**Rix's Creek Extension Project (SSD 6300)  
Response to Submissions Addendum**

I refer to your two emails of 21 December 2016 providing, firstly, a Response to Submissions Addendum (RTSA) report and, secondly, a response to the Department's request for additional information for the Rix's Creek Extension Project.

## Attachment A

Figure B (Rev3): Proposal : Final Landform Areas (Fixed Infrastructure Excluded)

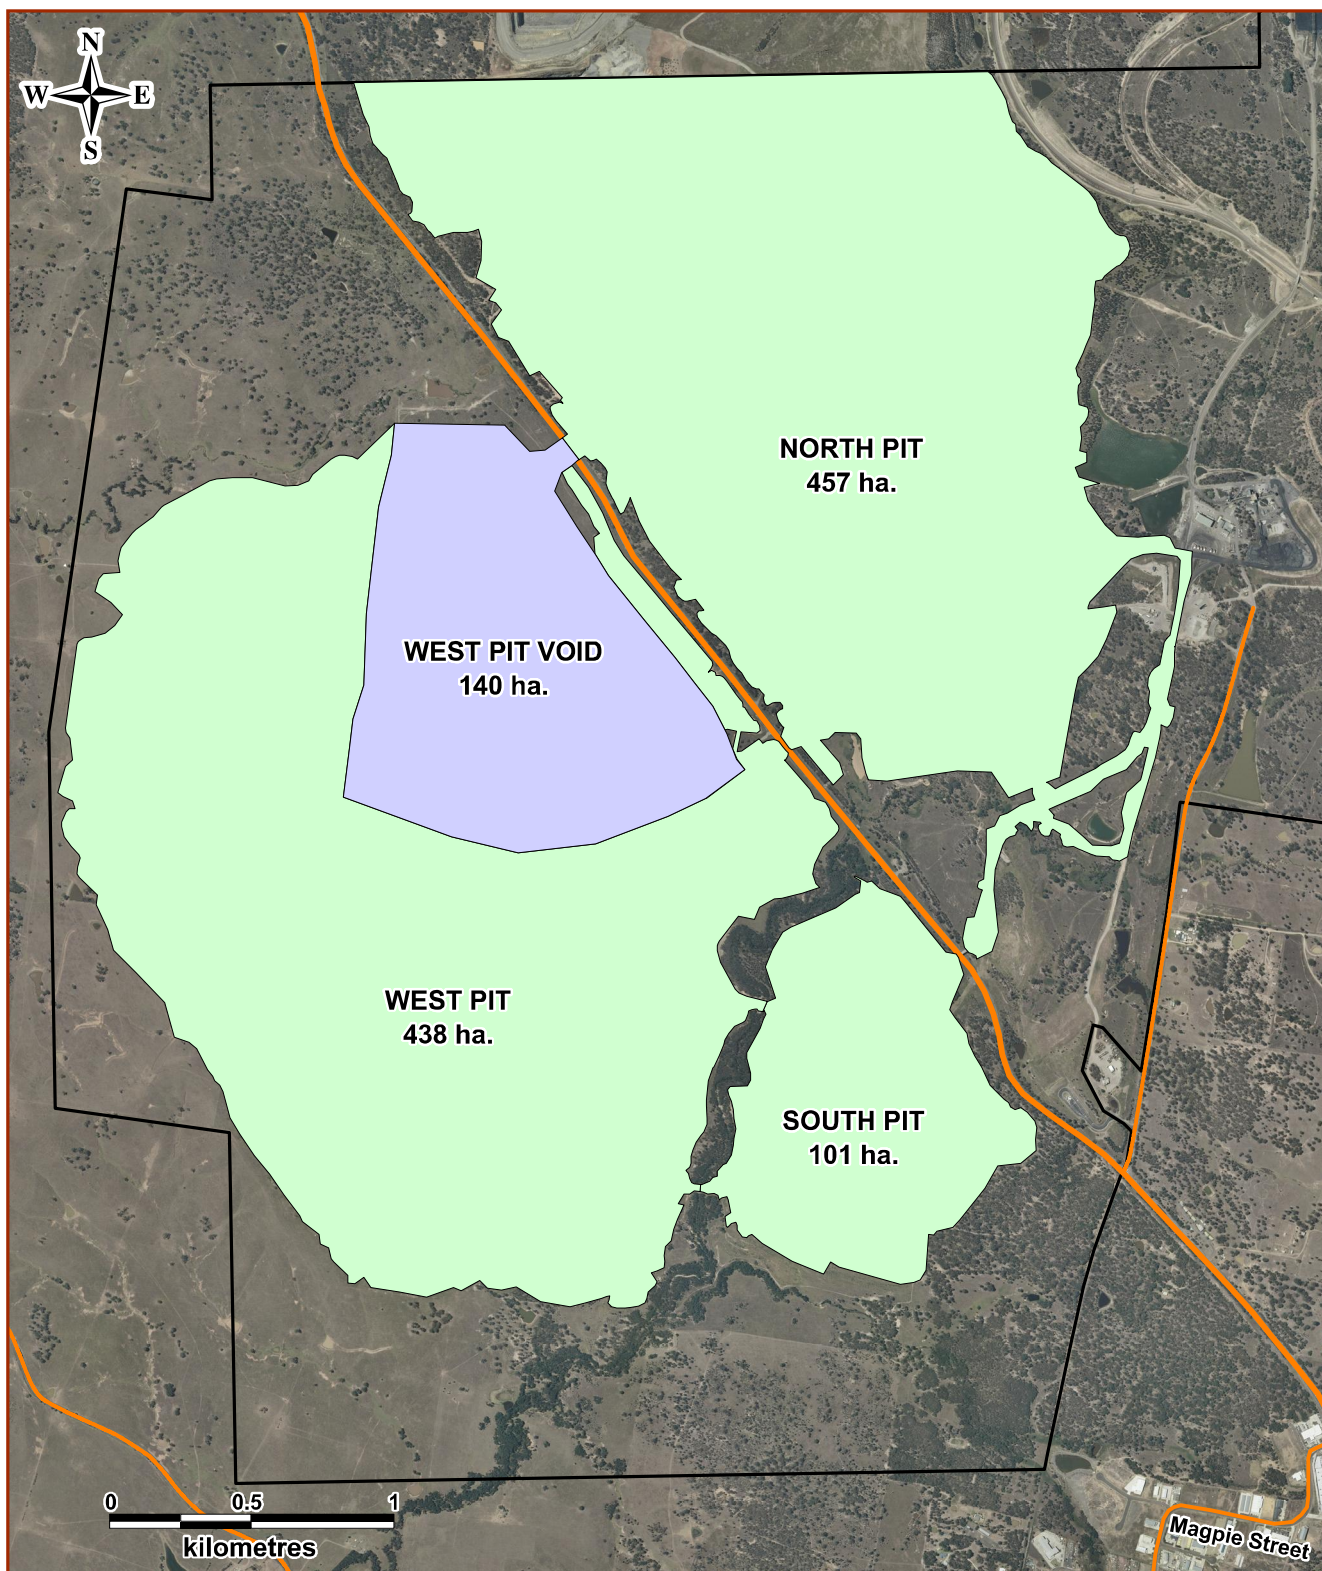
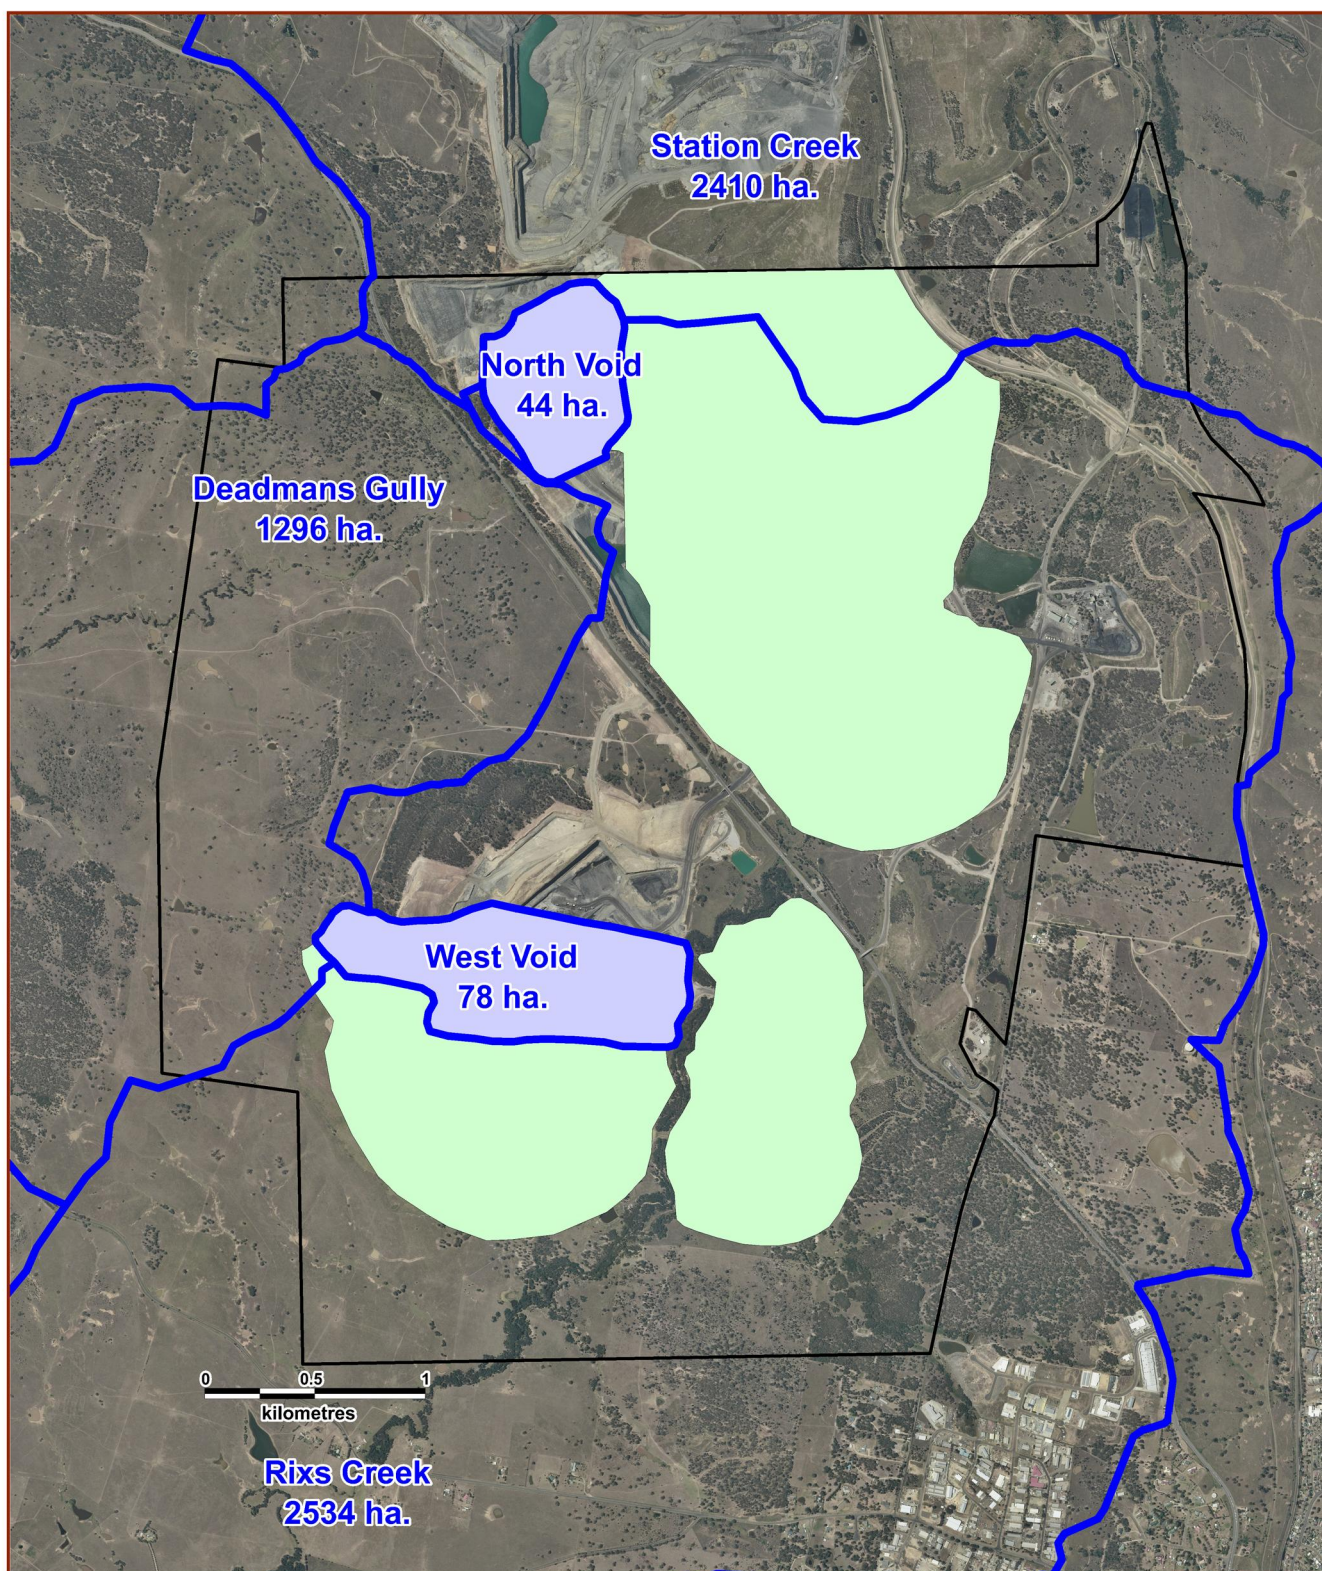
The additional information received 21 December 2016 quantifies the change in the catchment area in the unnamed tributary near Deadman's Gully; however there is no assessment of the significance of this change to the hydrology of the watercourse or to downstream water users. Additional information should be provided that analyses the significance of this change, including any mitigation or management measures to minimise impacts to the hydrology of this watercourse and downstream water users.
